Project #: 1008528 Application #: 12DRB-70373
Project Name: Paradise North
Agent: Terra West LLC Phone #:

DEVELOPMENT REVIEW BOARD – SPEED MEMO

DRB CASE NO: 1008528

Site Plan for Building Permit:

ENGINEER'S SEAL RONALD R. BOHANNAN P.E. #7868	SPECTRUM ASSISTED LIVING	DRAWN BY BJF
	SITE PLAN FOR SUBDIVISION	DATE 10/28/11
 5571 MIDWAY PARK PLACE NE ALBUQUERQUE, NM 87109 (505) 858-3100 www.tierrowestllc.com		2011026-SPB
		SHEET # C1
		JOB # 2011026

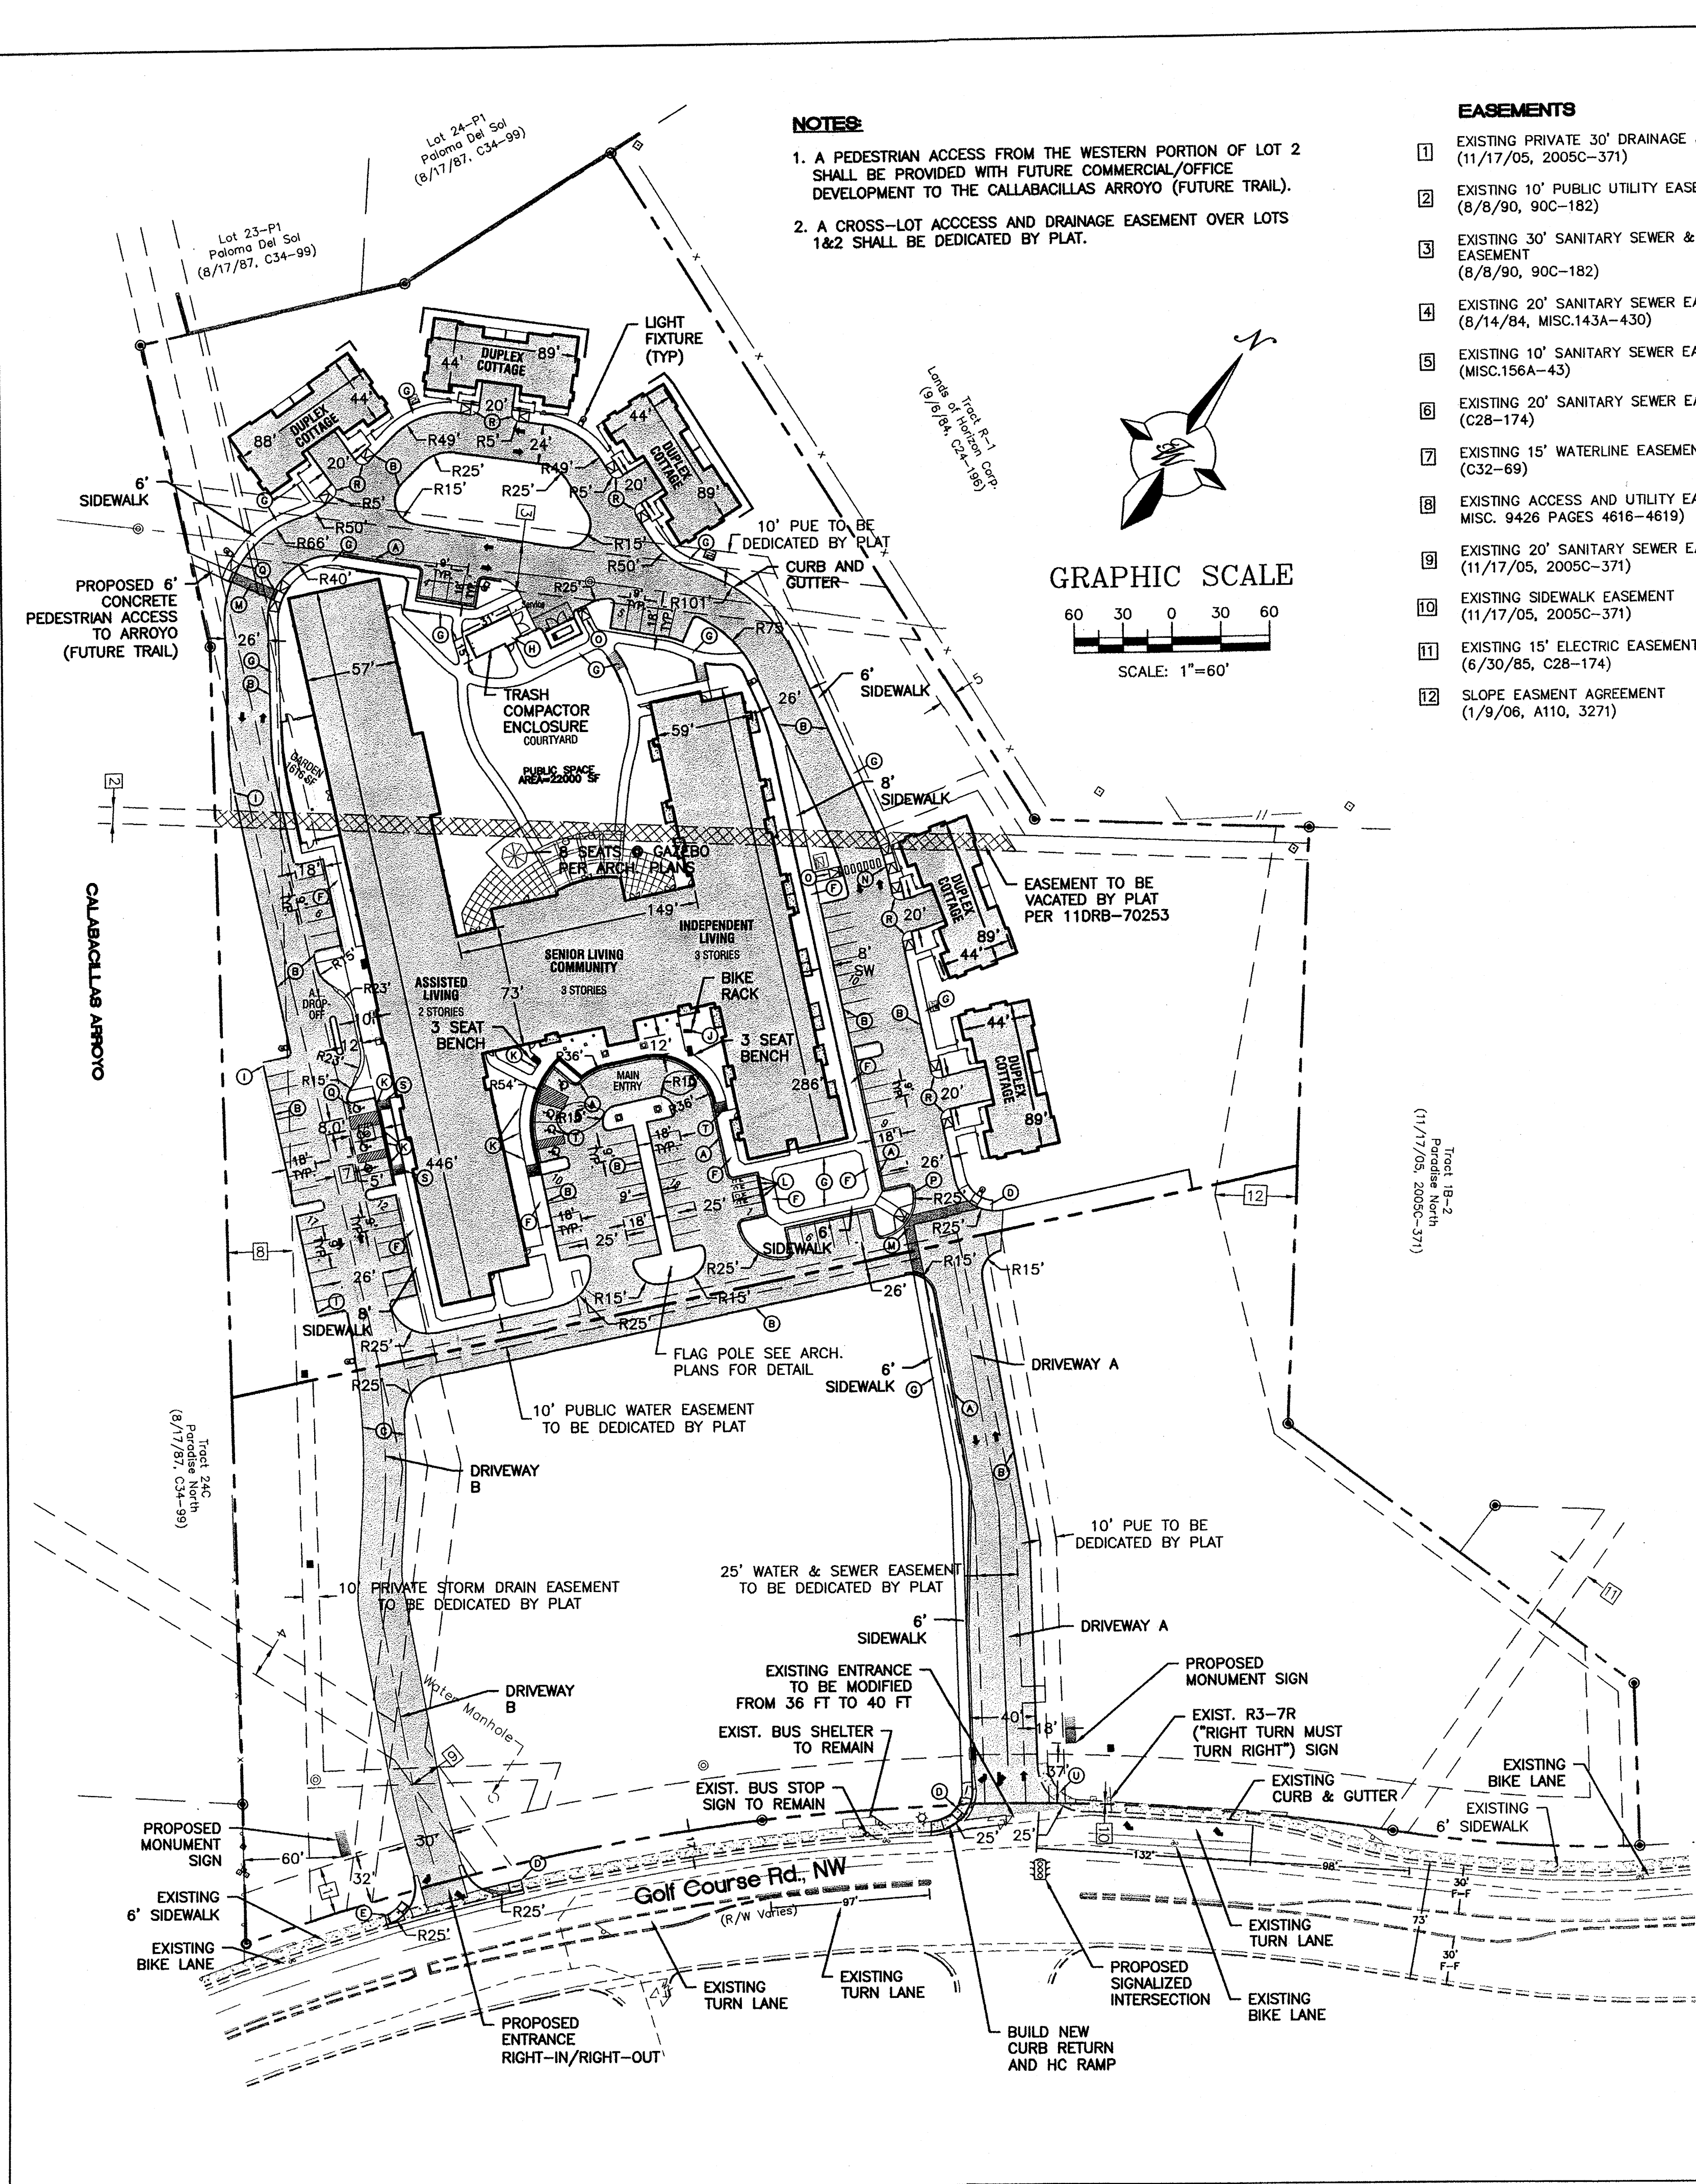
All proposed improvements shown on the Site Plan for Subdivision must be noted as illustrative only or removed (EPC Conditions, 5.c).

Plat of
 Tracts 1B-1-A and 1B-1-B
Paradise North
 Albuquerque, Bernalillo County, New Mexico
 October 2011

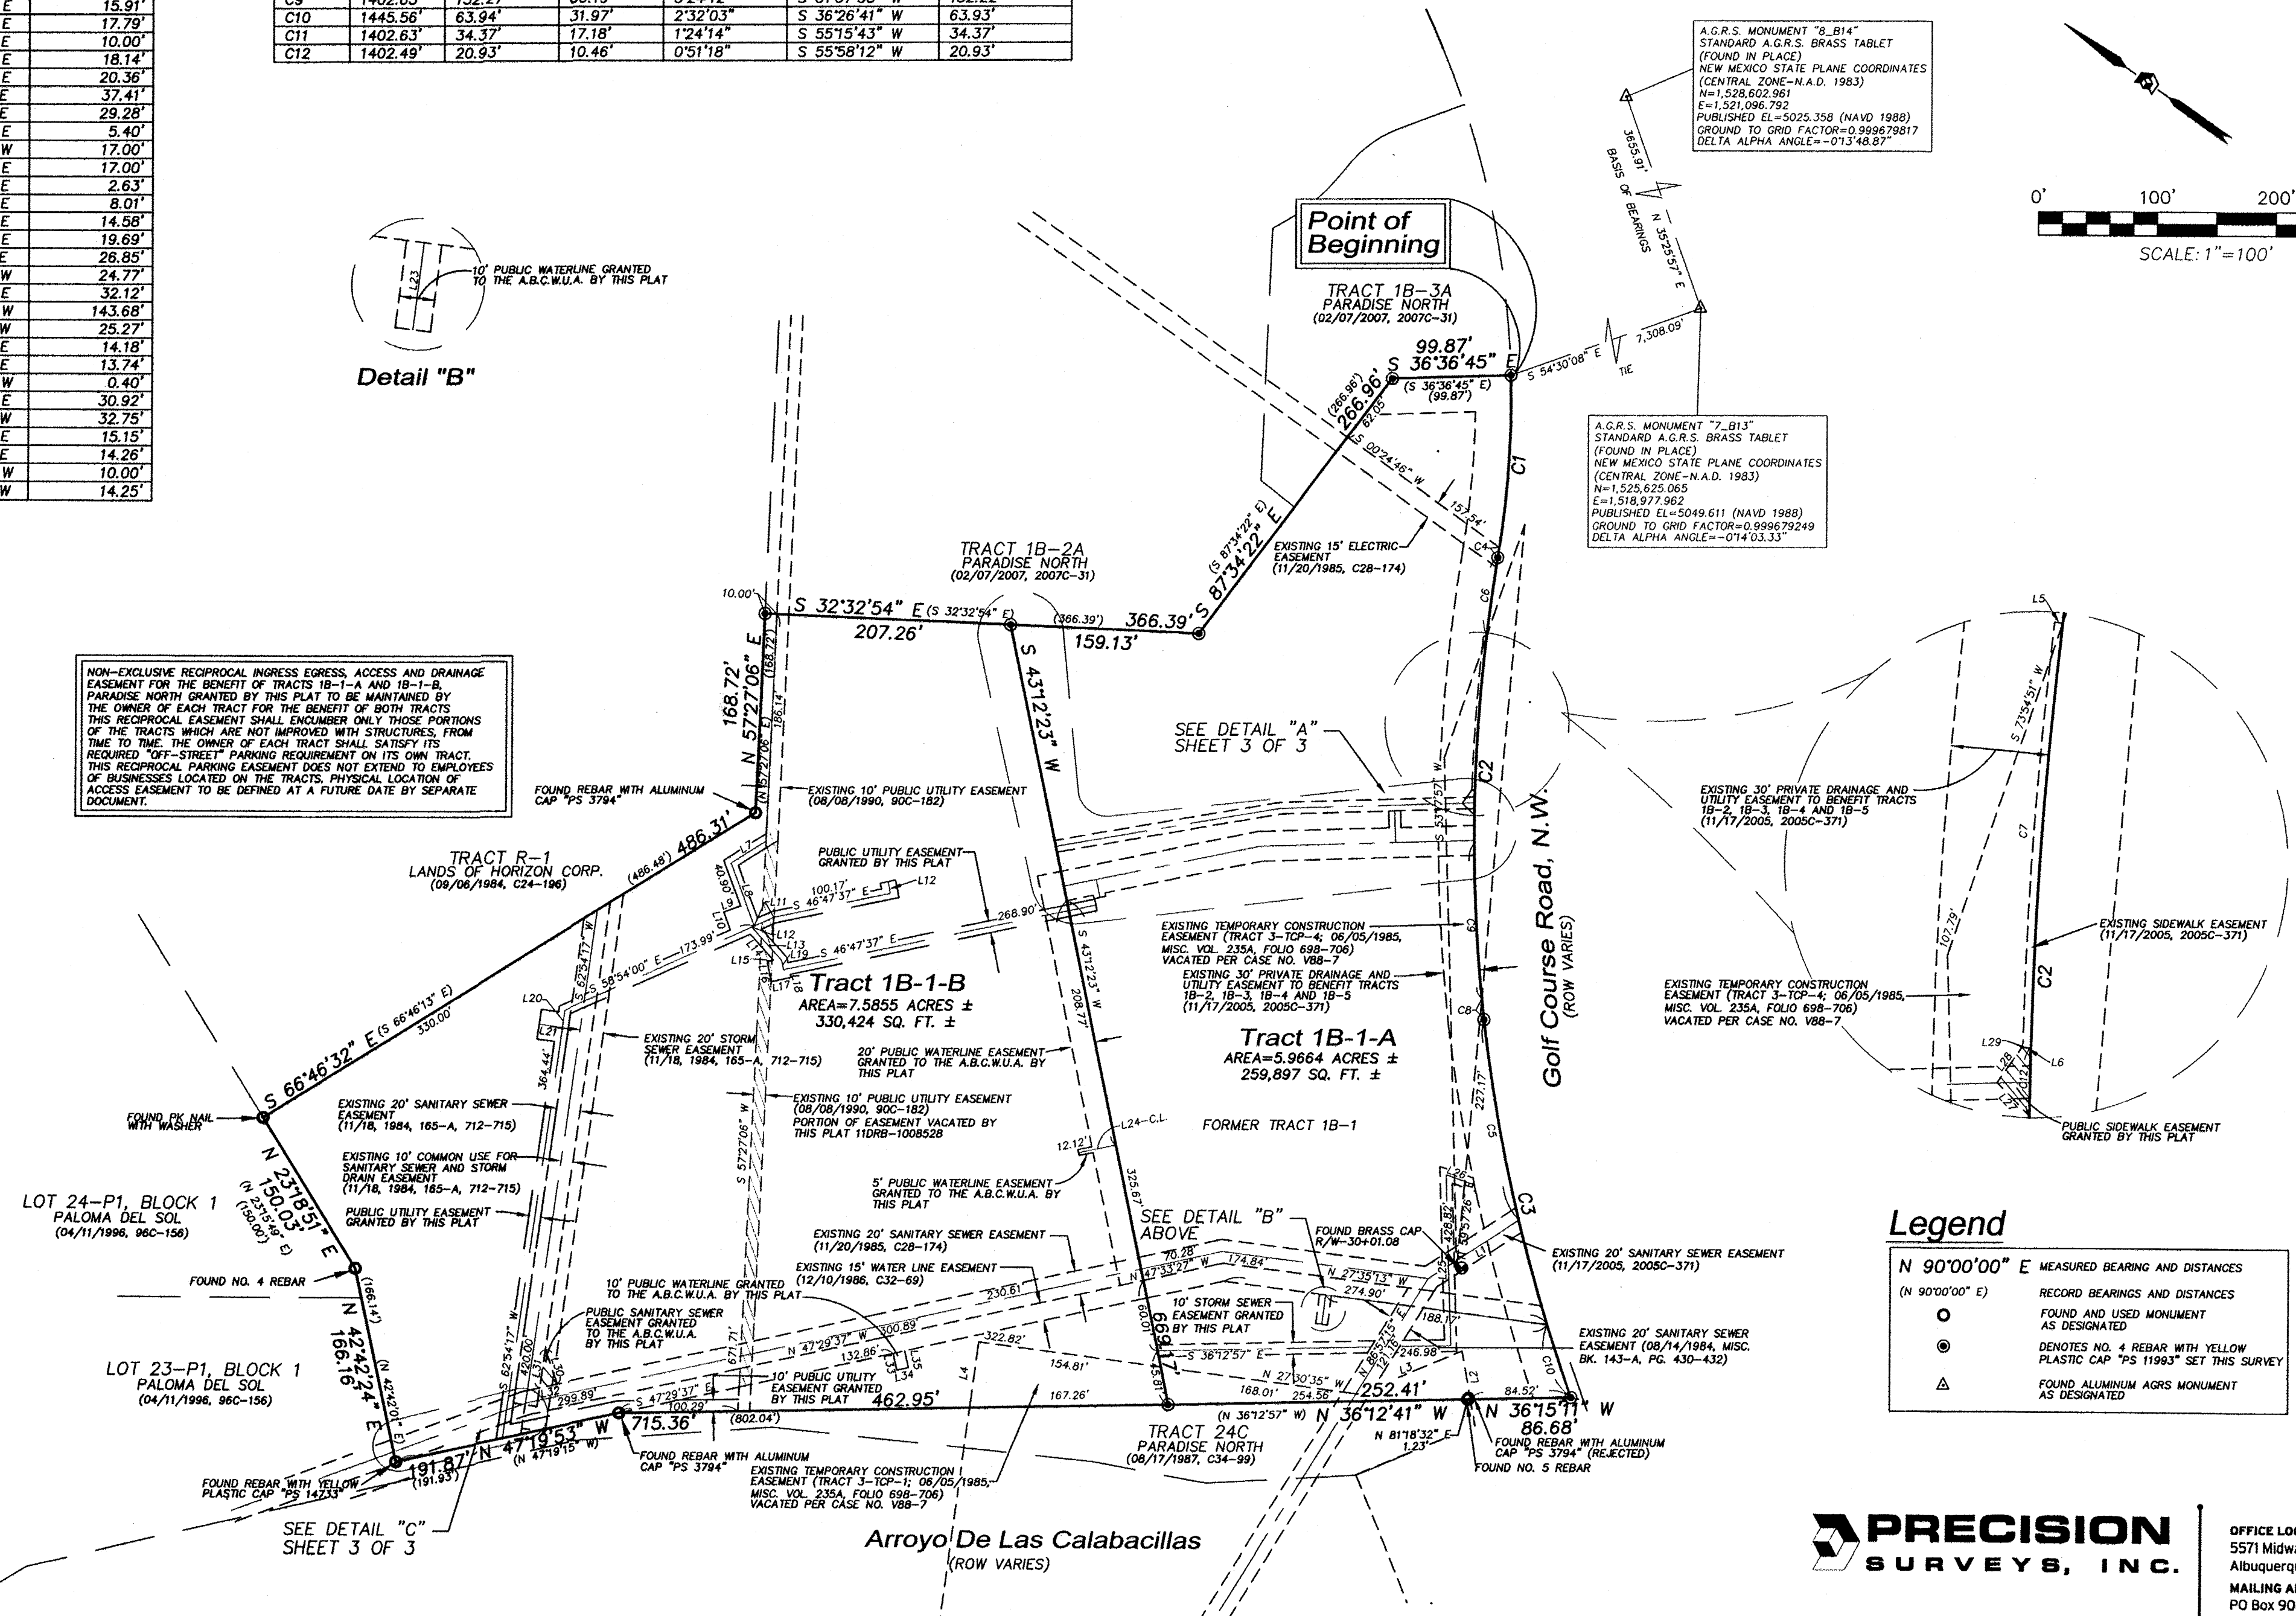
Please provide Easement for Pedestrian Access on plat

| | | SHEET # C2 |

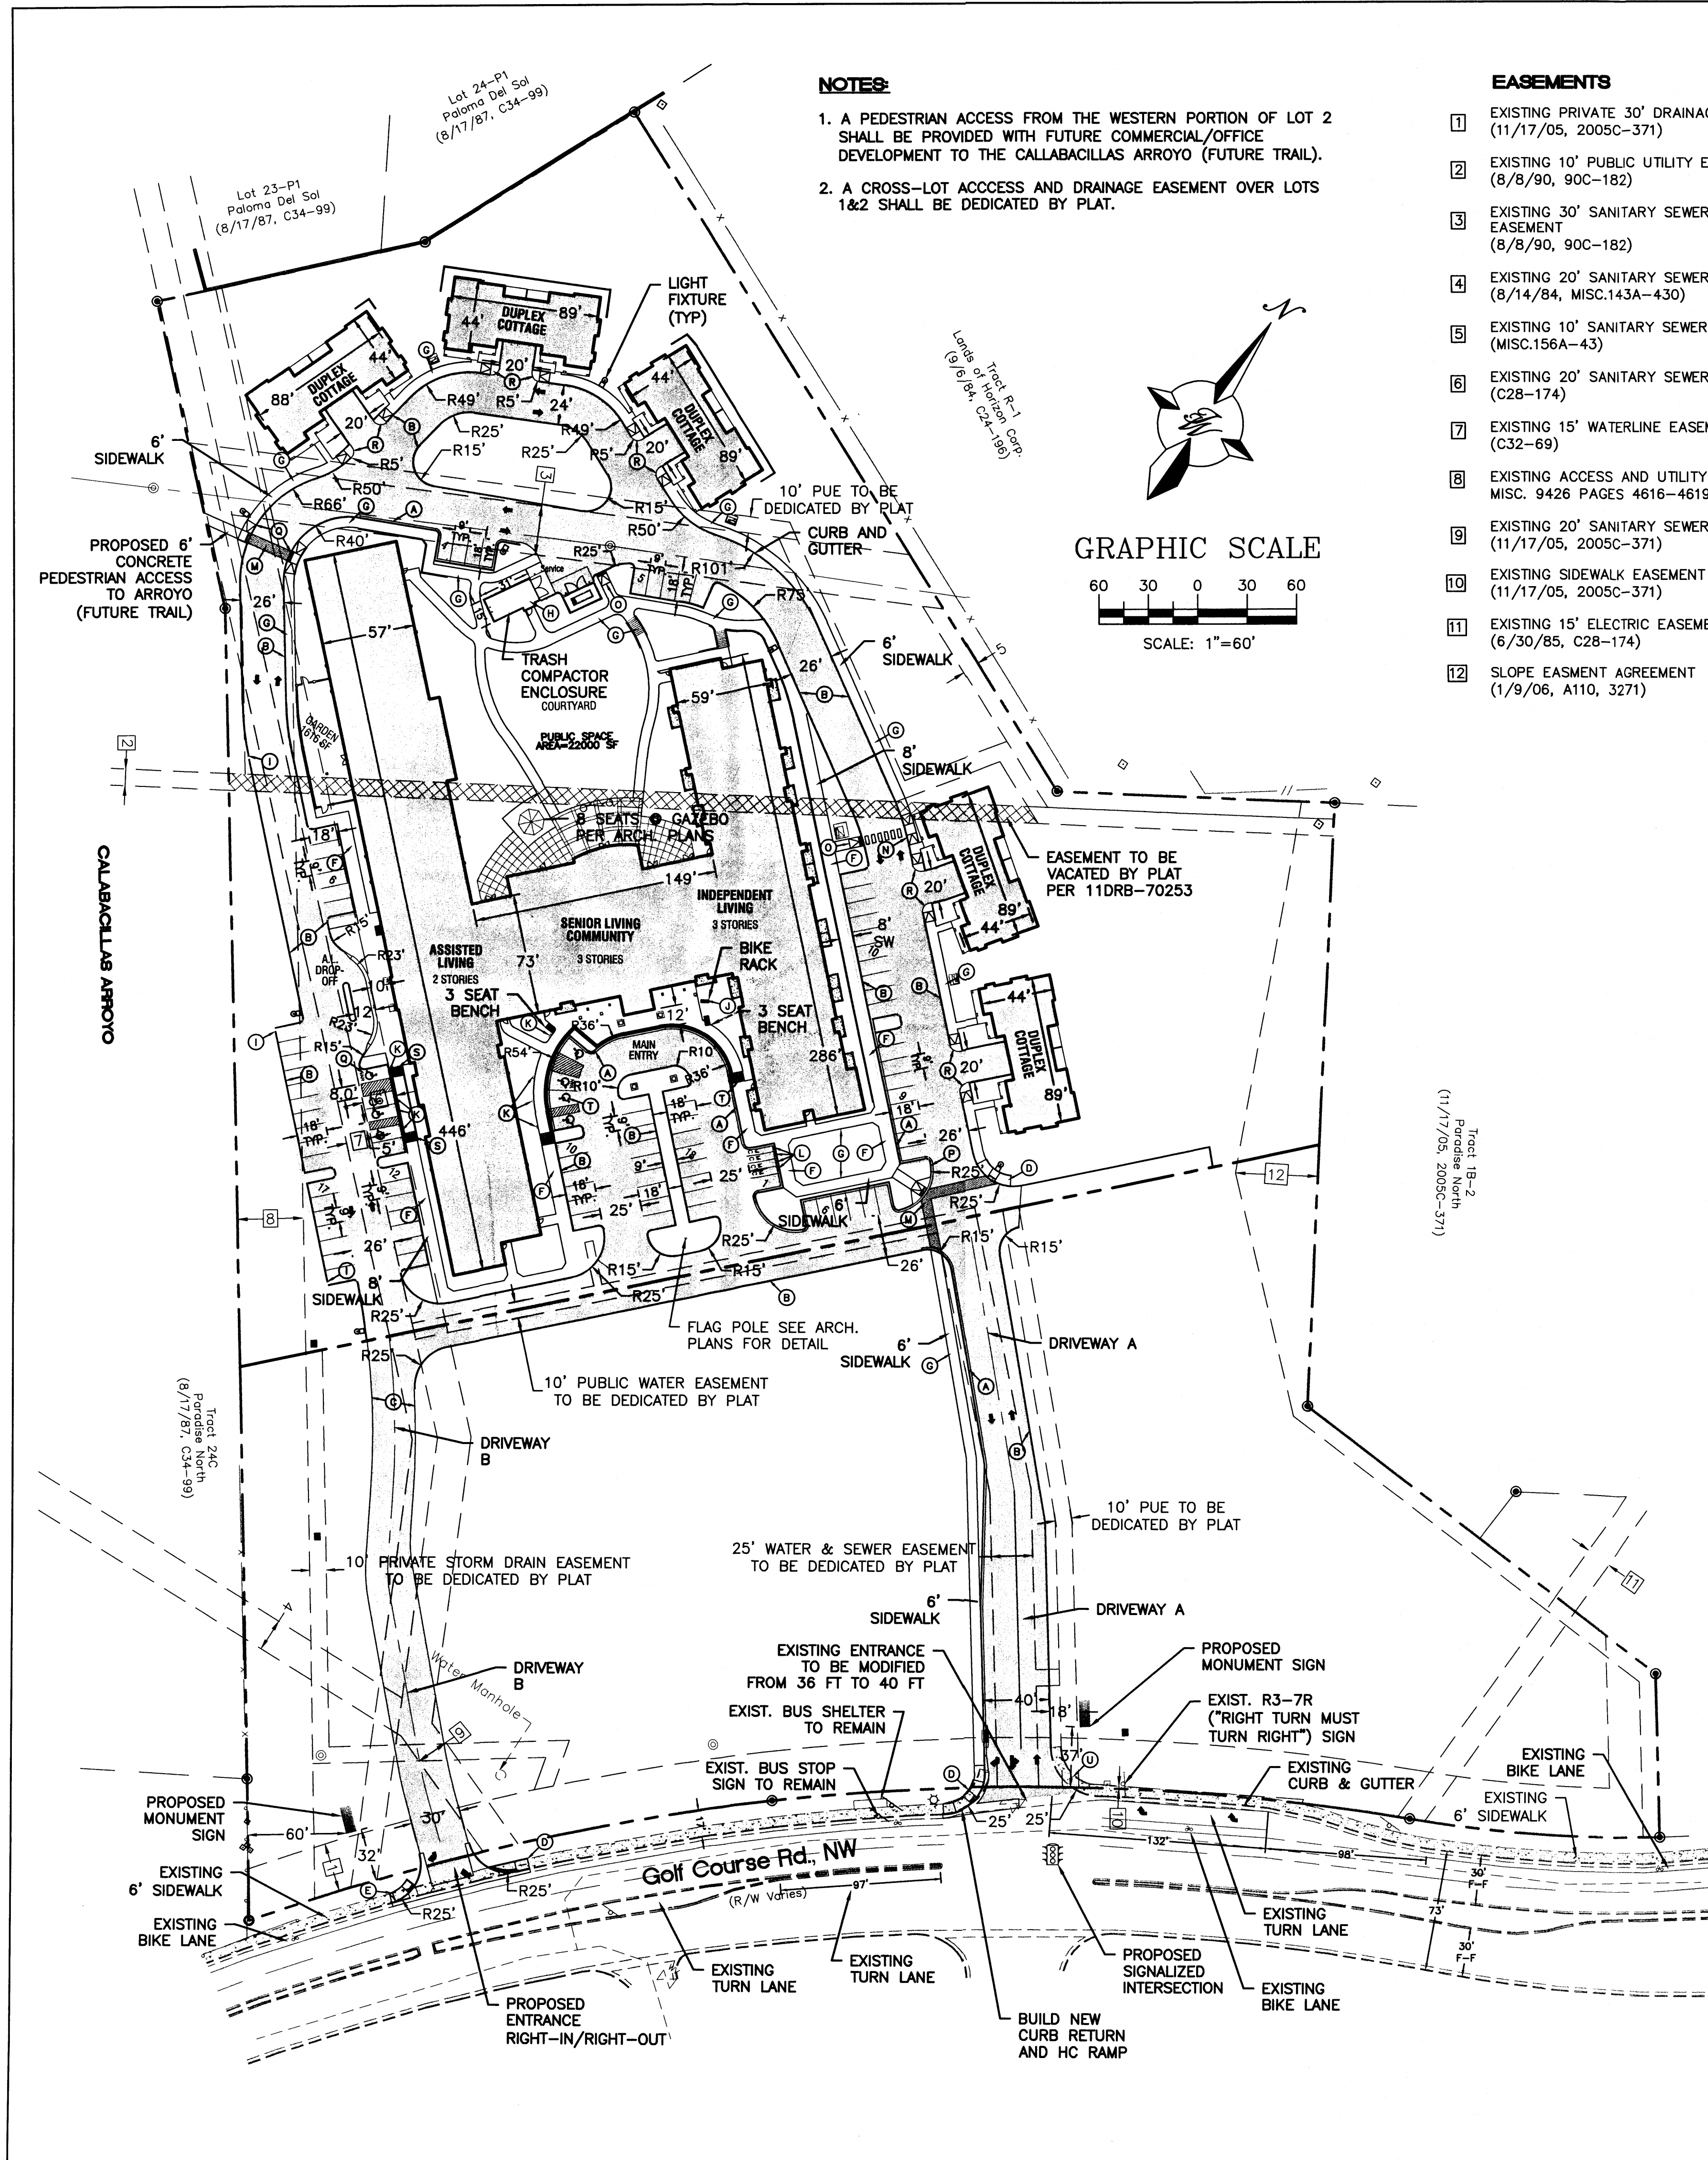
Keyed note C indicates a proposed berm crossing driveway B. Please clarify.
The proposed ramps at the entrances do not match the details provided.
The infrastructure list indicates that curb and gutter must be built along Golf Course Road. Please clarify.
Define the width of the handicapped parking stalls located on the curve.
Call out all radii.
